From: Sue Howell <Sue.Howell@arun.gov.uk>
Sent: 19 May 2022 17:28
To: Planning.Responses <Planning.Responses@arun.gov.uk>
Cc: Katie Sharp <Katie.Sharp@arun.gov.uk>
Subject: Planning Consultation on: A/270/21/OUT

Response to Planning Application

Application ref: A/270/21/OUT

Location: Land off Arundel Road Angmering

Commercial Access - General Arrangement
1no Footway, North Side

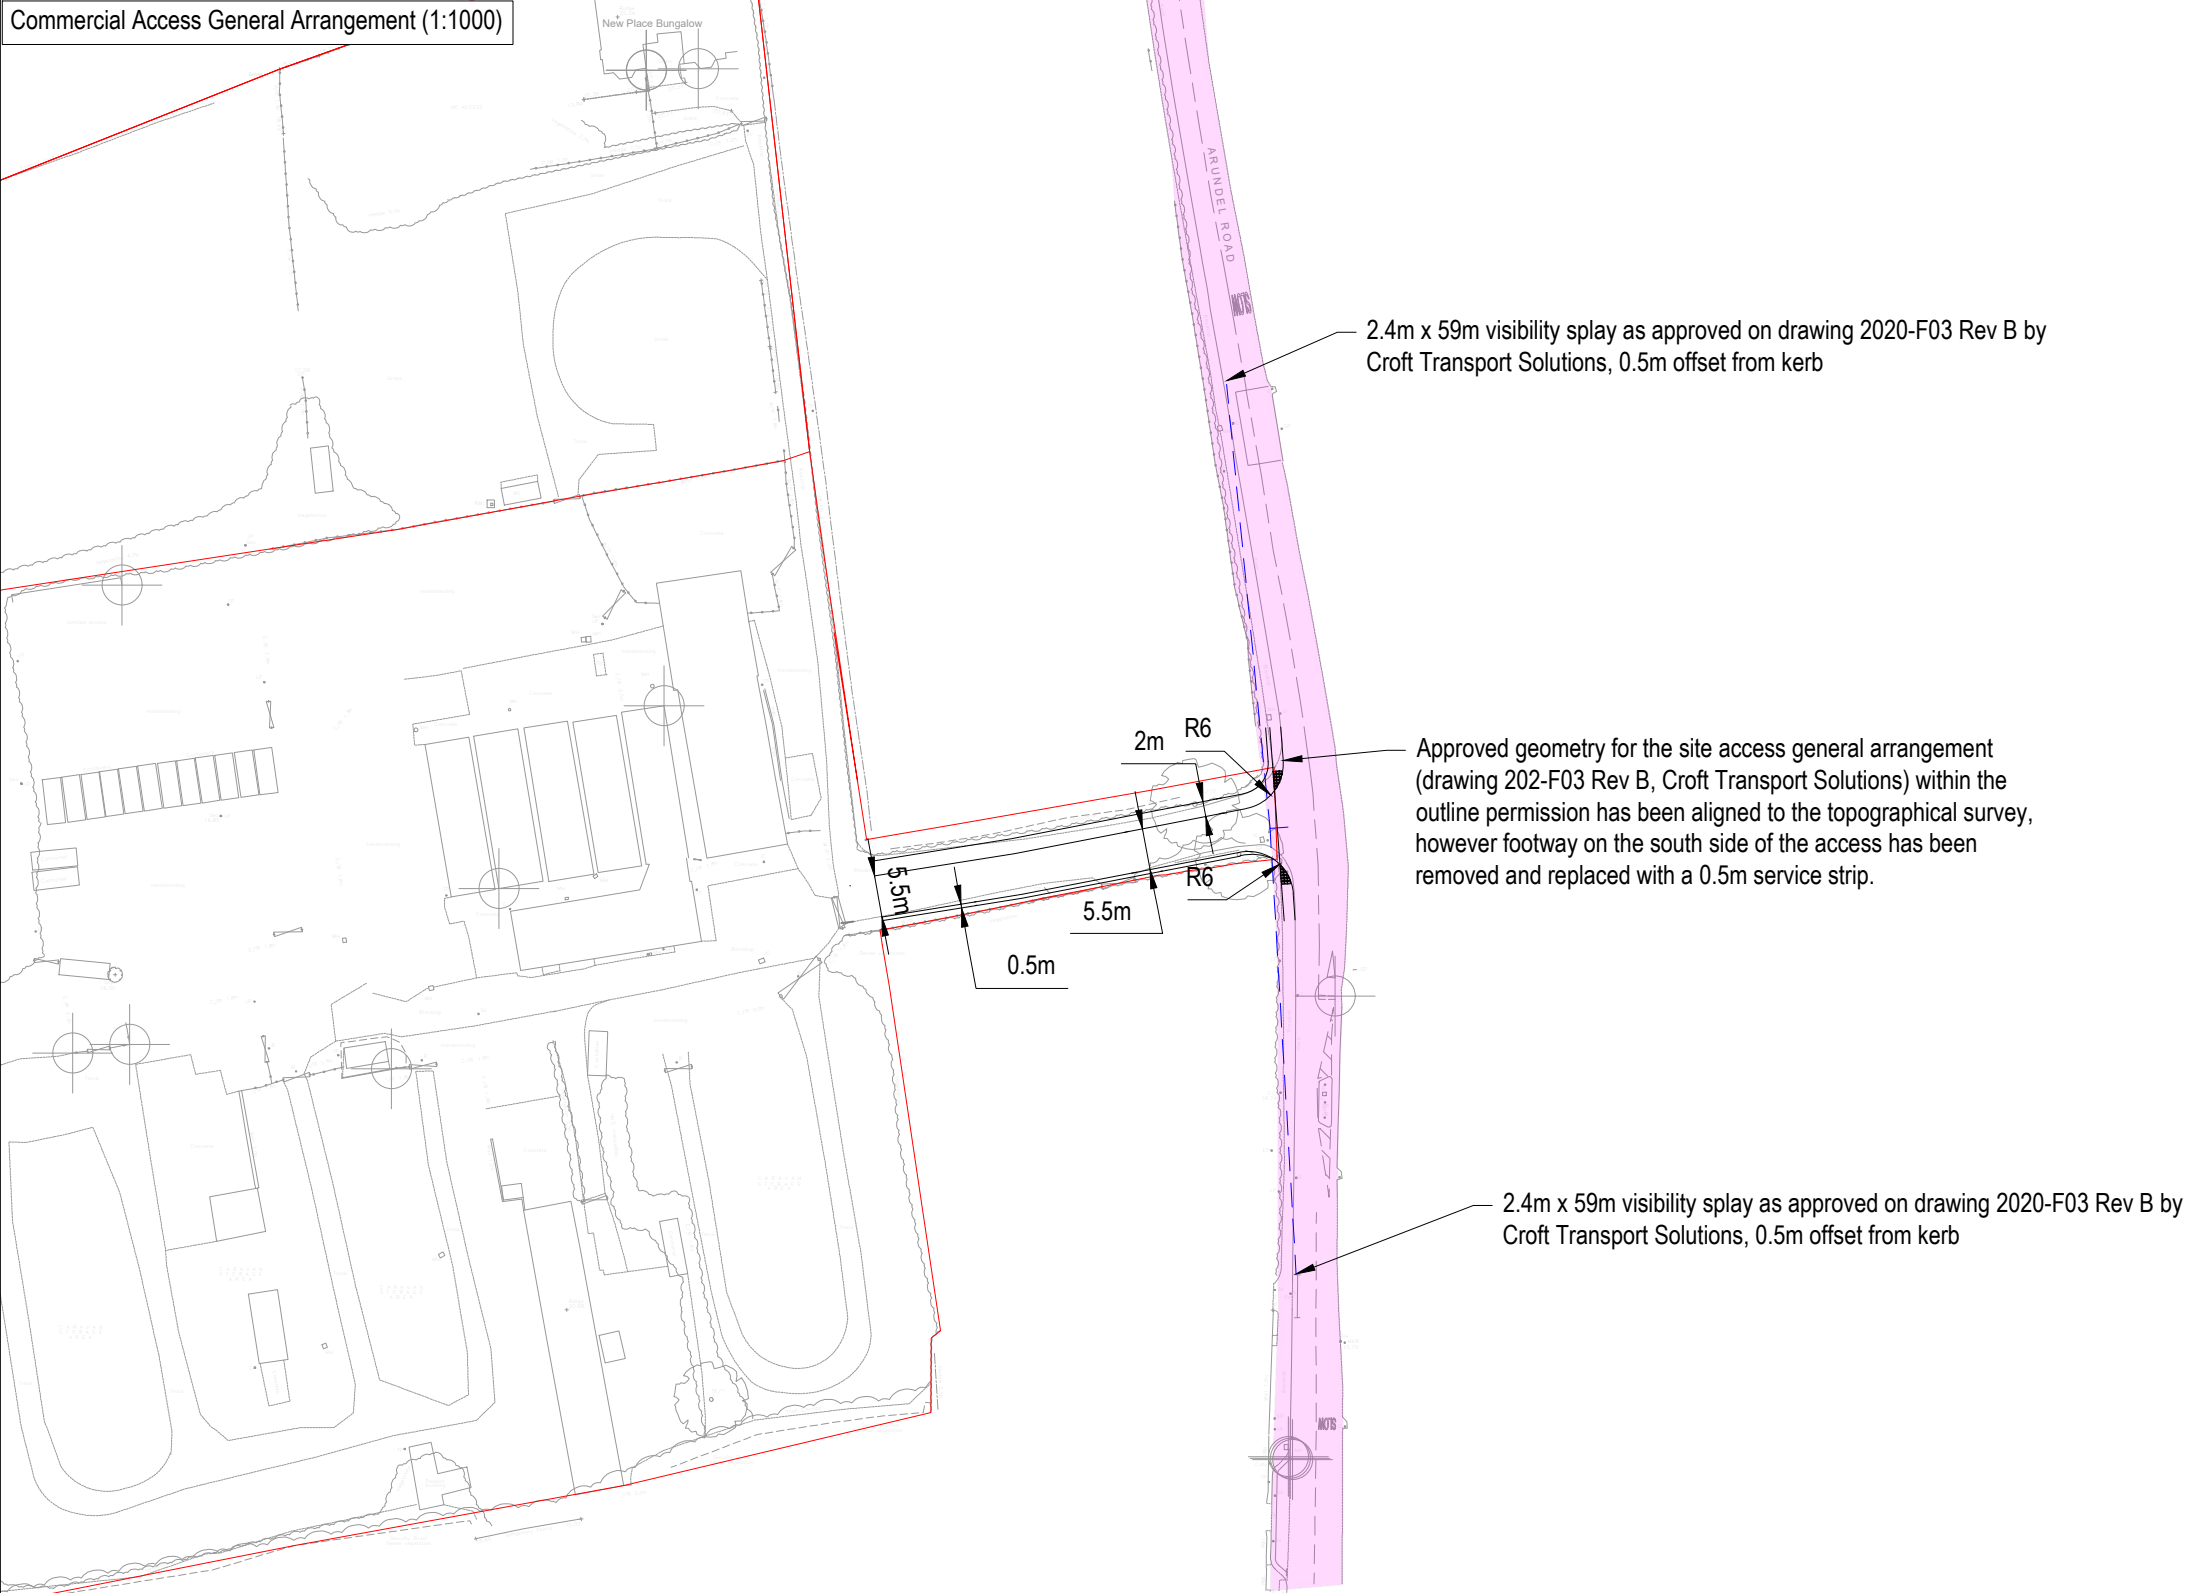
Full details are shown for the residential part of the site, but only outline permission is sought for the commercial element. The latter is in approximately the same location as the outline, however it was believed that an access route through the commercial area to the sports hub had yet to be concluded and this application would appear to disregard this consideration.
